**KIRKLEES COUNCIL
TOWN AND COUNTRY PLANNING ACT 1990
HIGHWAYS DEVELOPMENT MANAGEMENT**

PLANNING REF 2018/62/90051/W0/VG
CATEGORY Small Major

PROPOSAL PART DEMOLITION OF EXISTING BUILDING,ERECTION OF NEW BUILDINGS AND REUSE OF EXISTING BUILDINGS TO FORM B1,B2 & B8 USES

LOCATION COMMUNITY SPIRIT
BRITANNIA MILLS
BRITANNIA ROAD
SLAITHWAITE
HUDDERSFIELD
HD7 5HE

SWEPT PATH ANALYSIS
10m RIGID TRUCK

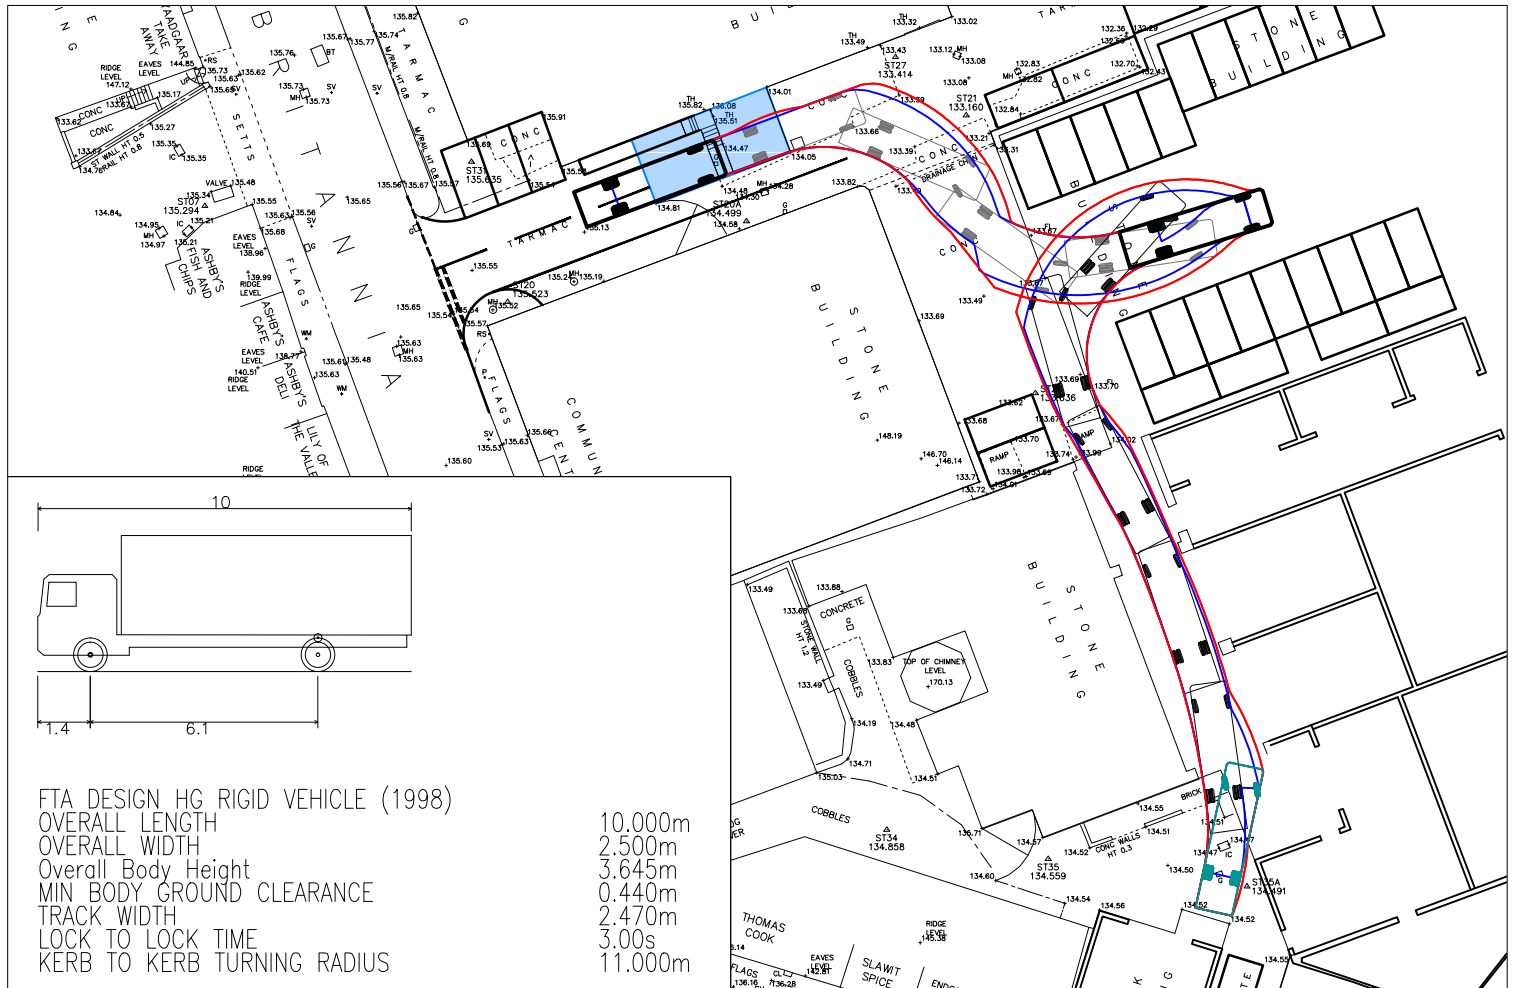
Turning movements into and out of the development access will be difficult with larger vehicles needing to use the full width of Britannia Road. The site will be inaccessible for larger vehicles

including 16.5m articulated vehicles. Turning and manoeuvre within the site will also be difficult for larger vehicles.

BRITANNIA MILLS
PROPOSED SITE ACCESS

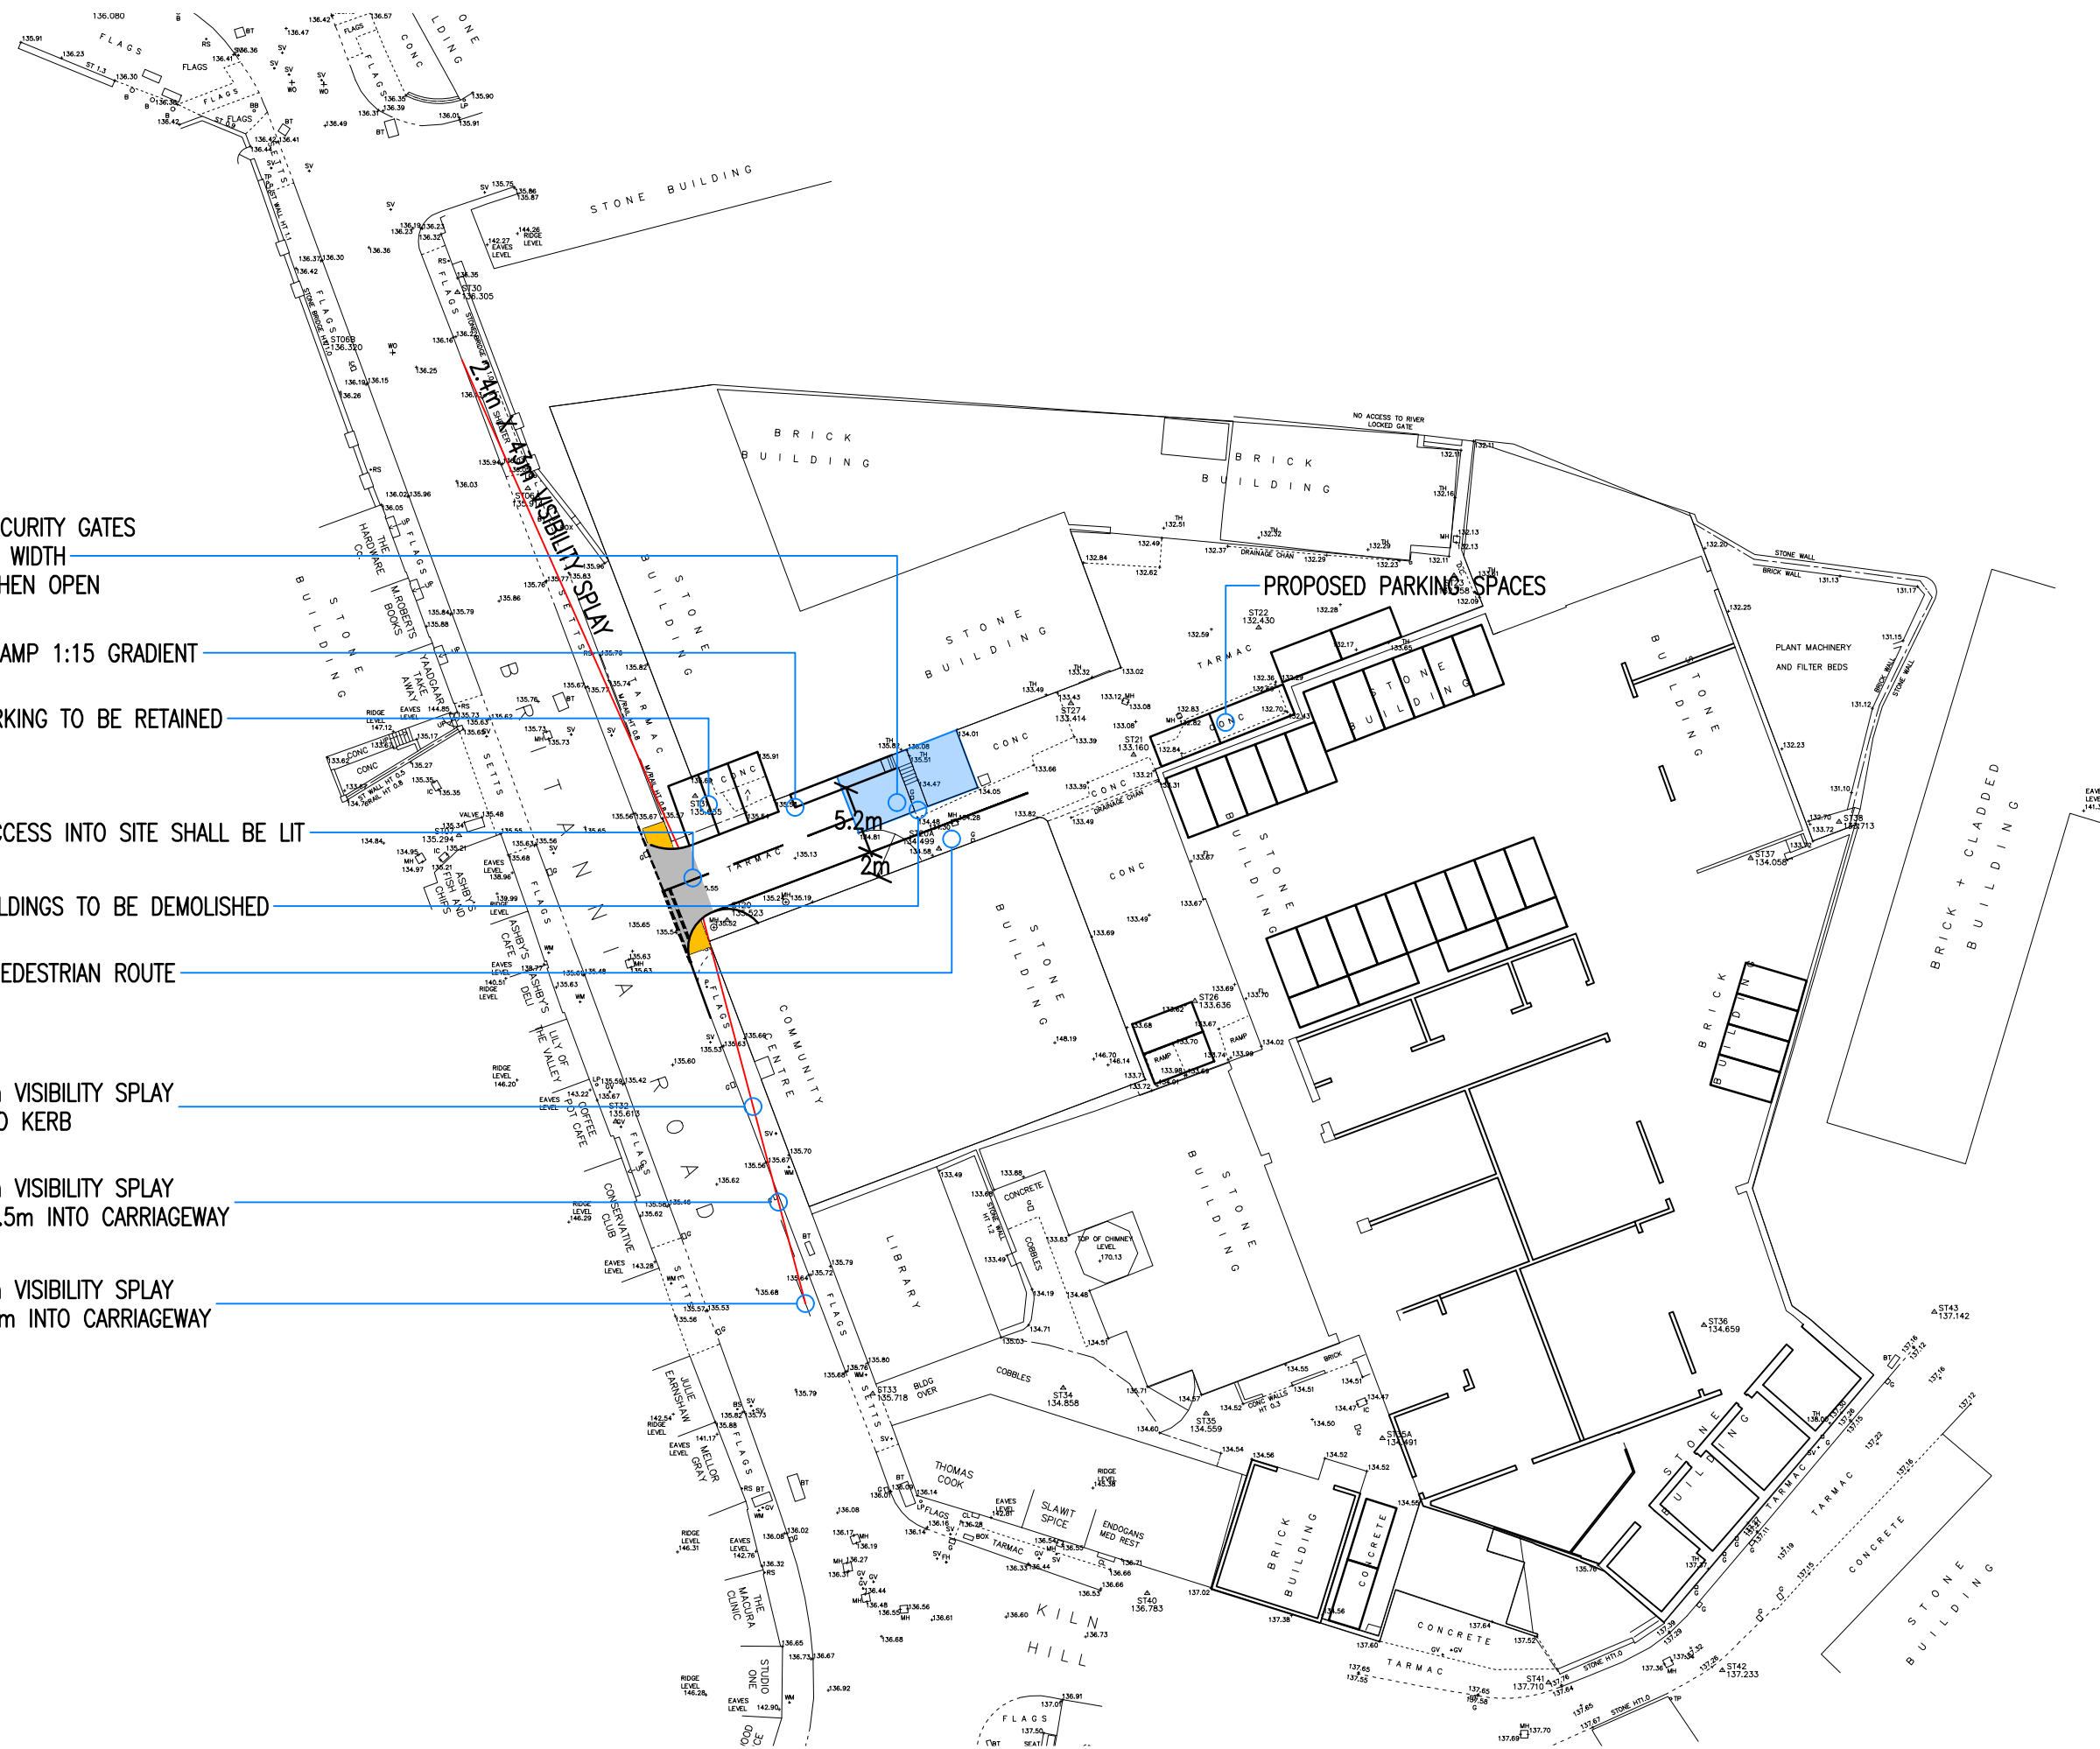
The existing access is narrow and insufficient in width to allow two vehicles to pass.

There are no pedestrian provision into the site

Sight lines from the access are poor to the left when exiting the proposed access onto Britannia Road

Inter-visibility between drivers and pedestrians on the Britannia Road nearside footway is poor and sub-standard

The improvement to the access on to Britannia Road as approved in 2013 and the possibility of providing an exit for the whole of the development site onto Kiln Hill should be considered.
